2007-0086

66-68-High Street
Parking Lot

MEMORANDUM

Subject: Application ID: 2007-0086

Drawing Name: **Landscape / Layout Plan**

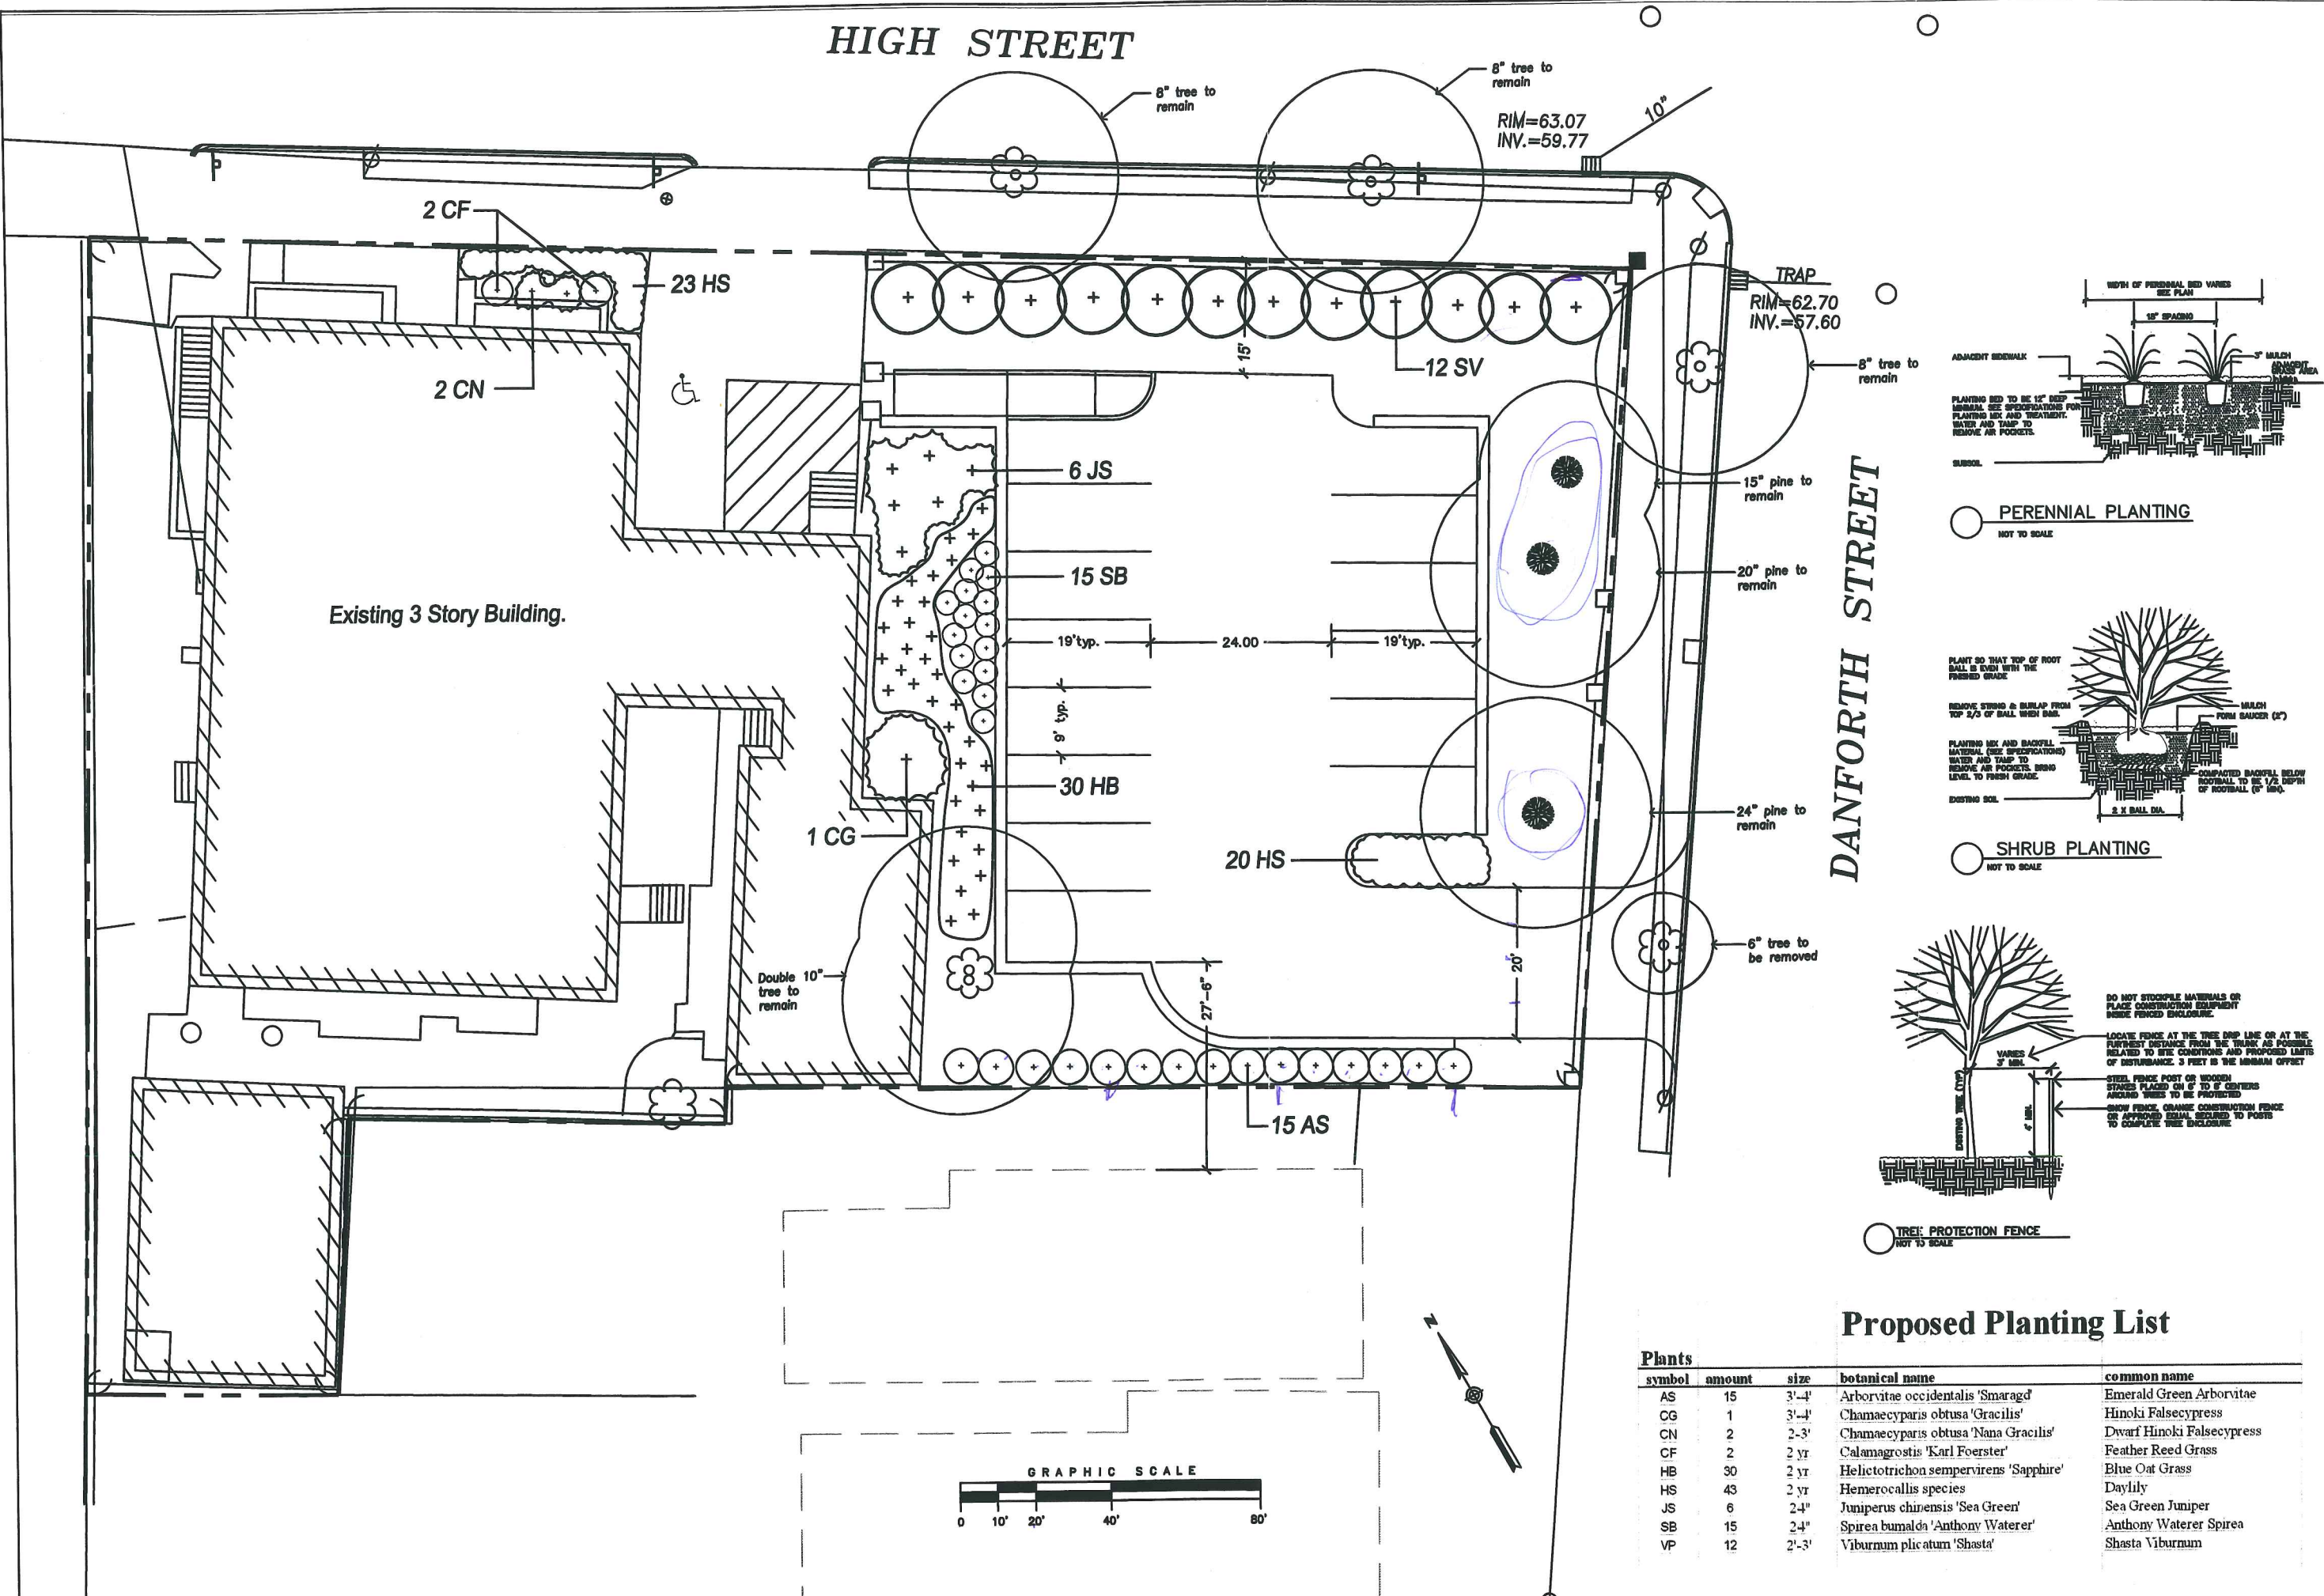
This accessory parking for USM is located in an R-6 Zone. This new parking is allowed and considered to be a conditional use (institution expansion) appeal to the planning board. I would want confirmation that no new lighting will be installed (none shown on submittal) or it will have to show compliance with section 14-340. I would like to see details of the curbing. Section 14-338 requires continuous curb guard at least six inches in height.

5. *"You will need to submit a separate landscaping plan including a description of measures to be taken to preserve existing mature trees and other vegetation on the project site."*

a. *"An 8-foot wide landscaping strip is encouraged to screen parking from surrounding properties."*

b. *"The total landscaped area within the parking area should comprise no less than 10% of the area designated for parking and vehicle circulation."*

c. *"If you submit revisions to the plan, maintain that no more than eight parking spaces occur in a row without a landscaped divider island, as is the case on the current plans."*

An updated landscape plan (sheet L-1) is enclosed which illustrates existing and proposed vegetation and indicates which trees are being preserved. There is a plant list of proposed plants, planting details and a tree protection detail which must be followed during construction to ensure protection of the preserved trees.

A row of shrubs is proposed along High Street which will attain an 8 foot width in maturity. A row of dense evergreens has been proposed along the neighboring property to the south that can achieve an 18 foot mature height. No buffer except the existing mature pine trees to remain is being proposed along Danforth Street to further protect their root systems.

The proposed landscaping meets and exceeds this requirement based on the following calculations. There is approximately 10,357 s.f. of area where the new parking is proposed. 4,616 s.f. of it landscaping and 5,841 s.f. of it paved surface. This makes the landscape area 45% of the total project area and equivalent to 80% of the proposed paved area.

We have not reconfigured the parking and have no more than 8 consecutive parking spaces.
